Your Ref: OWPC16517
Our Ref: FP/268/17/PL 26-10-2017
Please ask for:
Richard Temple

Detached 9No. bedroom annexe for Beachcroft Hotel with 9No. car parking spaces.
Boat Pound between Greenock Villa & The Gunpoint Clyde Road Felpham

Thank you for your internet representation made on 7th December 2017 which has been recorded as '**an objection**' with the comments as follows:

PROJECT	Gull Point Suites - On the Beach	DATE	20/09/17
TITLE	Roof Plan	DRG NO	IBA/480/10
SCALE	1 : 50	REVISIONS

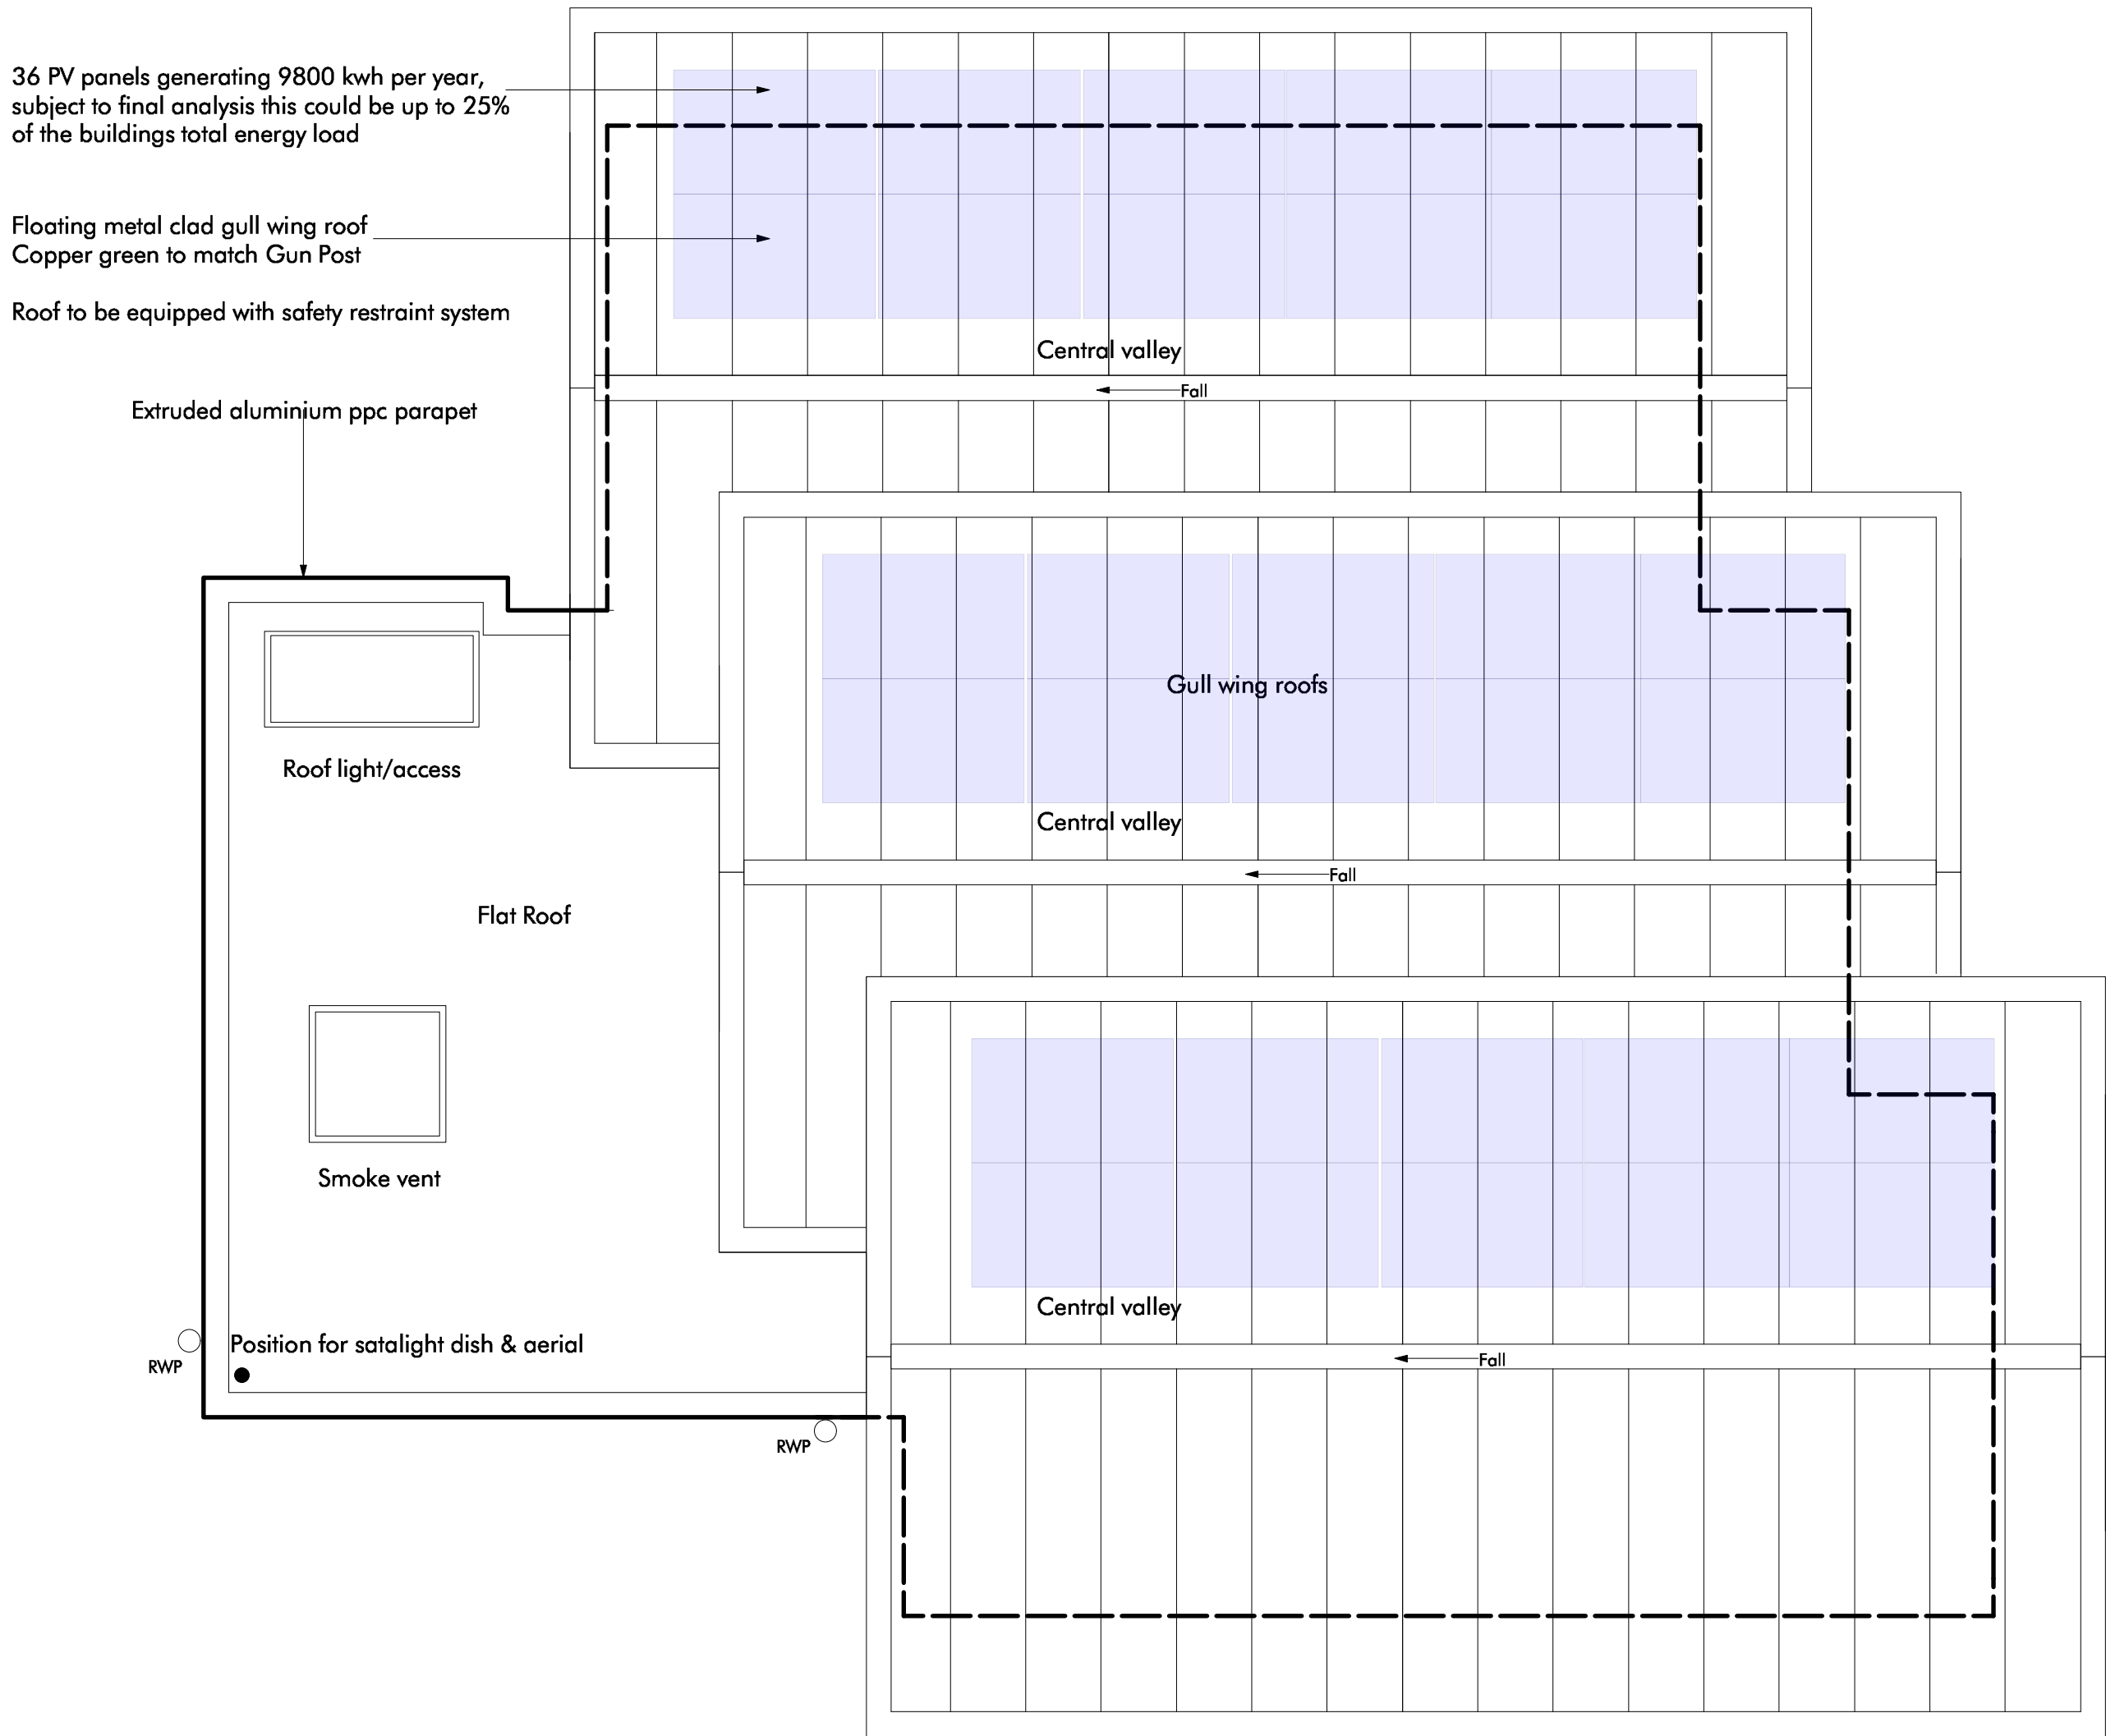
I object to the design - too big an impact visually, too near the promenade, not like anything else nearby and not in keeping with the area. It will detract from the local views along this part of the prom
And to the height which is 4 storeys not 3 as stated in the application with roof 'gull wings' adding additional height
And to the likelihood of additional noise from hotel guests . Will there be restrictions ?
And to the increased traffic in very small roads with reduced parking space available on Clyde Road with overspill on to other roads
I also have concerns about noise during the development.
